Re: 2024/62/92002/E

Erection of agricultural building; LAND OFF, WAKEFIELD ROAD, GRANGE MOOR, HUDDERSFIELD, WF4 4BG

The Coal Authority response: **Material Consideration**

Site Plan

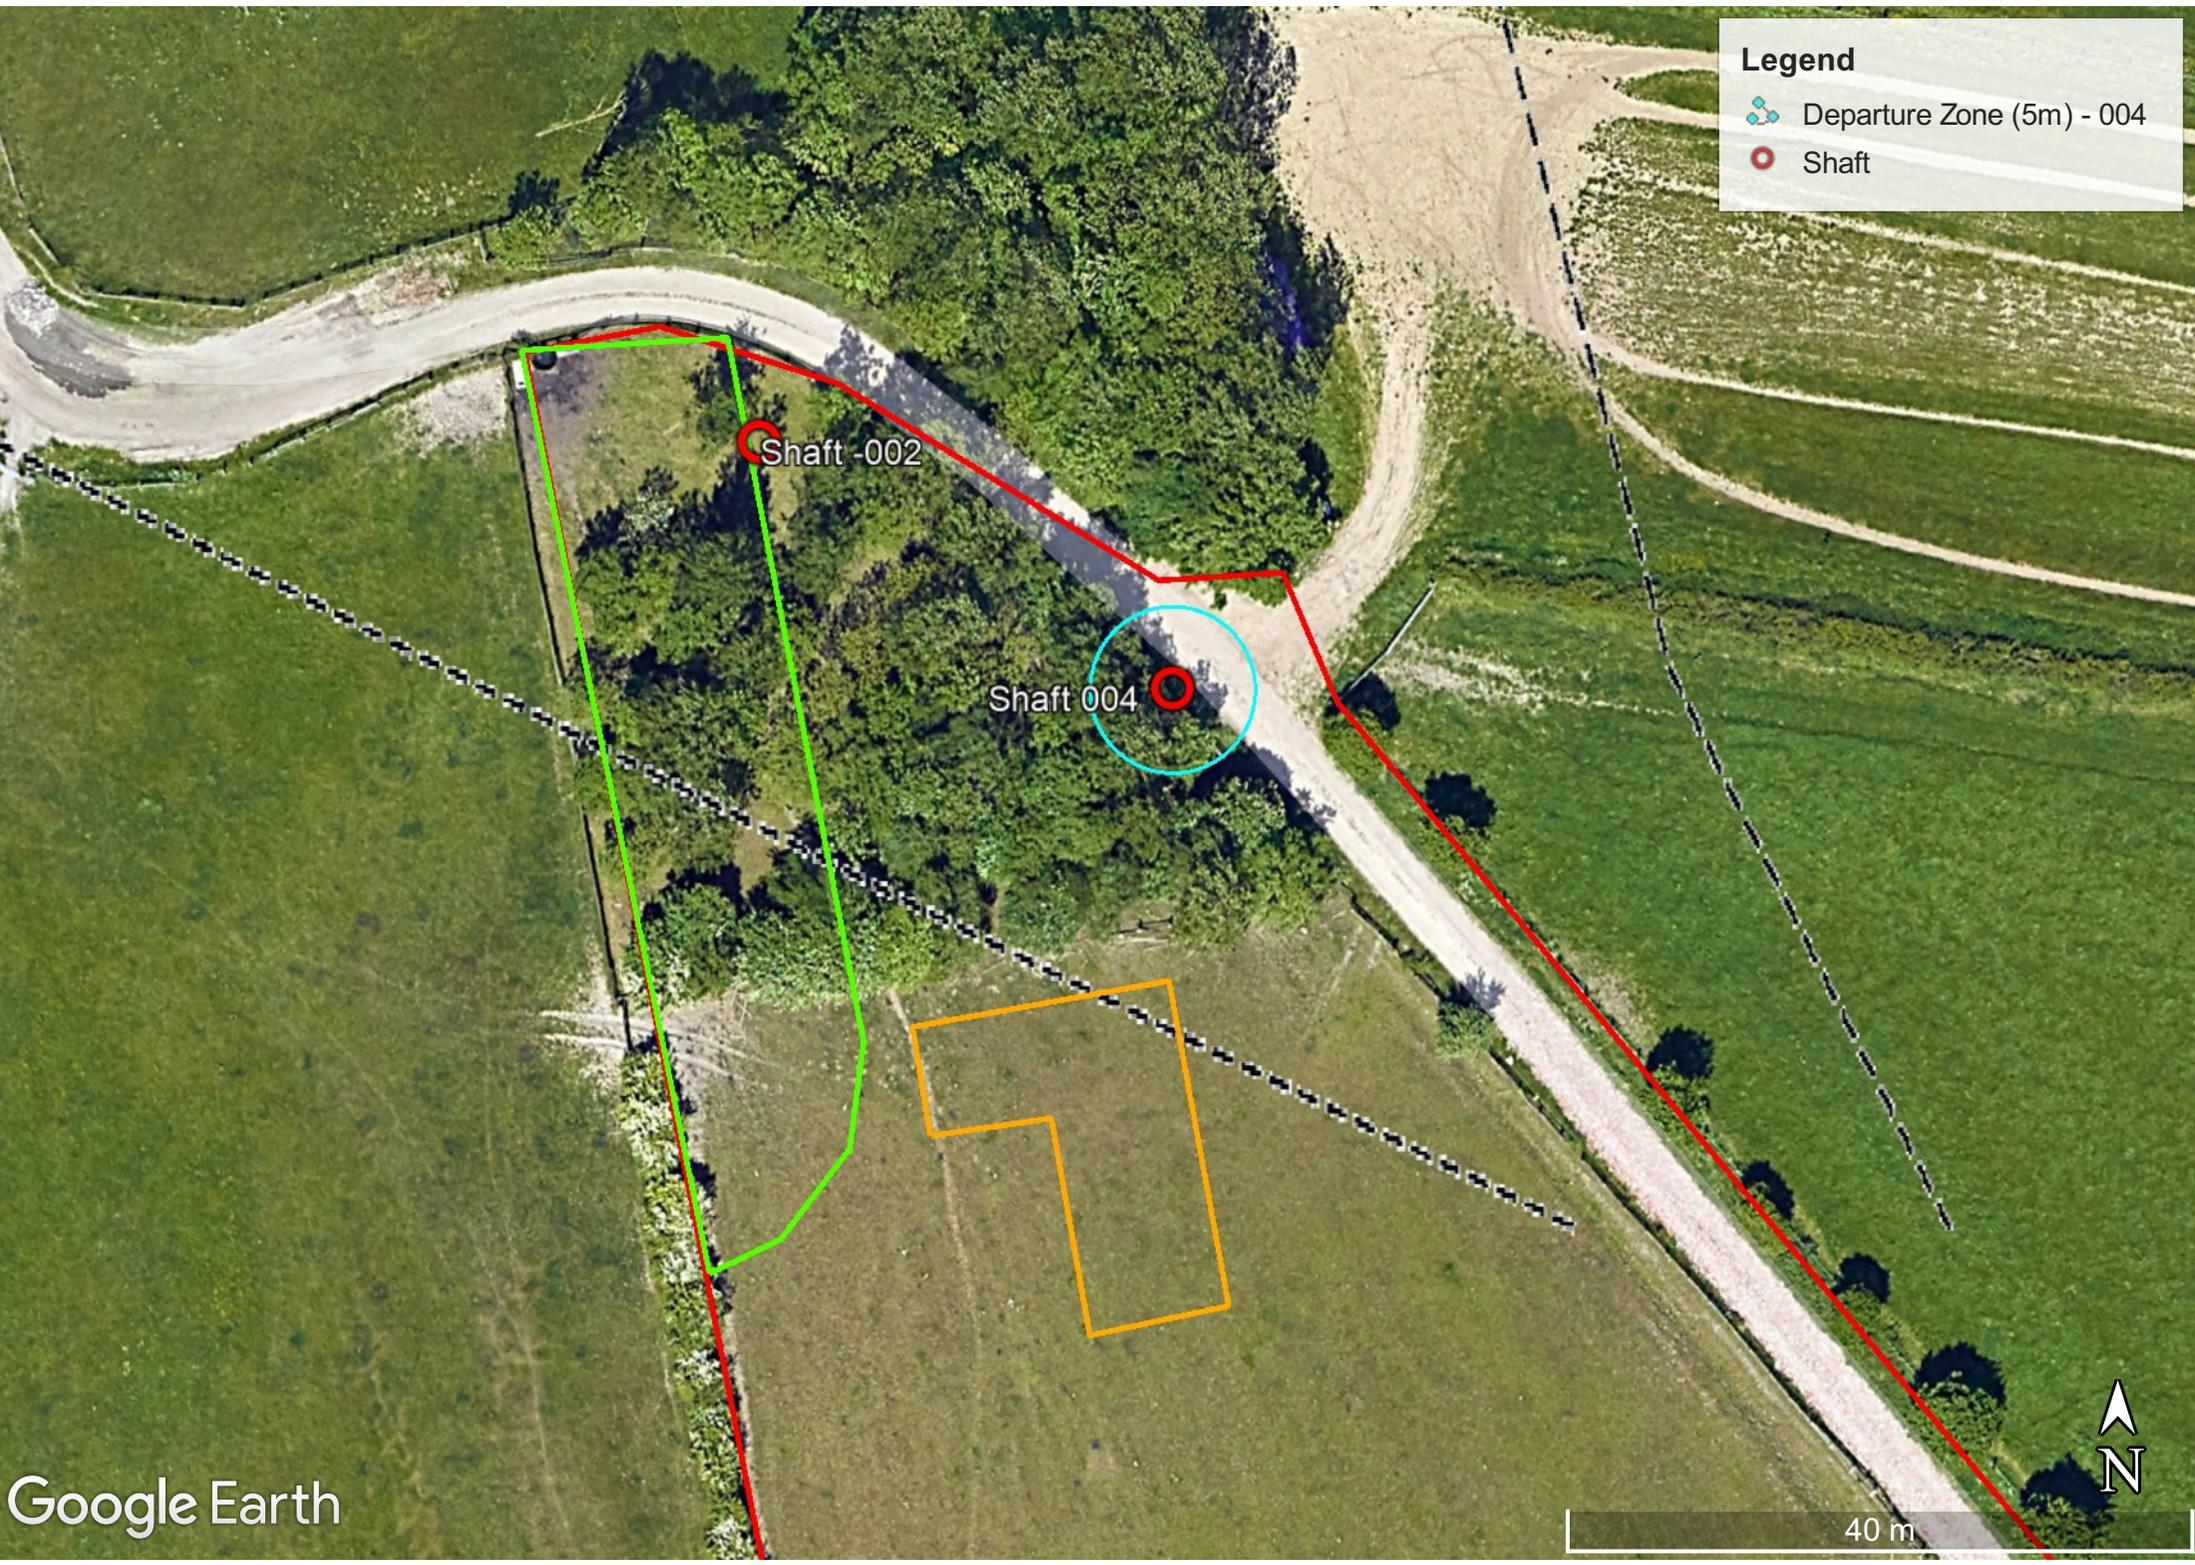
It is noted that Section 3.4 of the Report informs that whilst the two mine shafts are unlikely to affect the agricultural building, one of the mine entries (CA shaft ref: 423415-002) may be present beneath the proposed access and gated area. As stated above, based on the information that we hold for this mine entry (exact location recorded; was filled in 1970 and capped in 1974), the planning team at the Coal Authority do not consider that this feature or its resultant zone of influence would encroach on the access / gated area (Drawing No. 198_100 Revision D – Site Plan (Proposed)). However, we would recommend that vigilance be maintained by all site operatives during any ground preparation works. In the event that this or any unrecorded mine entry is found, all works should cease, the area should be made safe, and for a further assessment to be made by the applicant's geotechnical consultants (ie Rogers Geotechnical Services Ltd). The Coal Authority should also be notified.

In light of the above, the Coal Authority recommends the imposition of the following conditions:

1. No development shall commence until;

- a) a scheme of intrusive site investigations has been carried out on site to establish the risks posed to the development by past coal mining activity, and;
- b) any remediation works and/or mitigation measures to address land instability arising from coal mining legacy, as may be necessary, have been implemented on site in full in order to ensure that the site is made safe and stable for the development proposed.
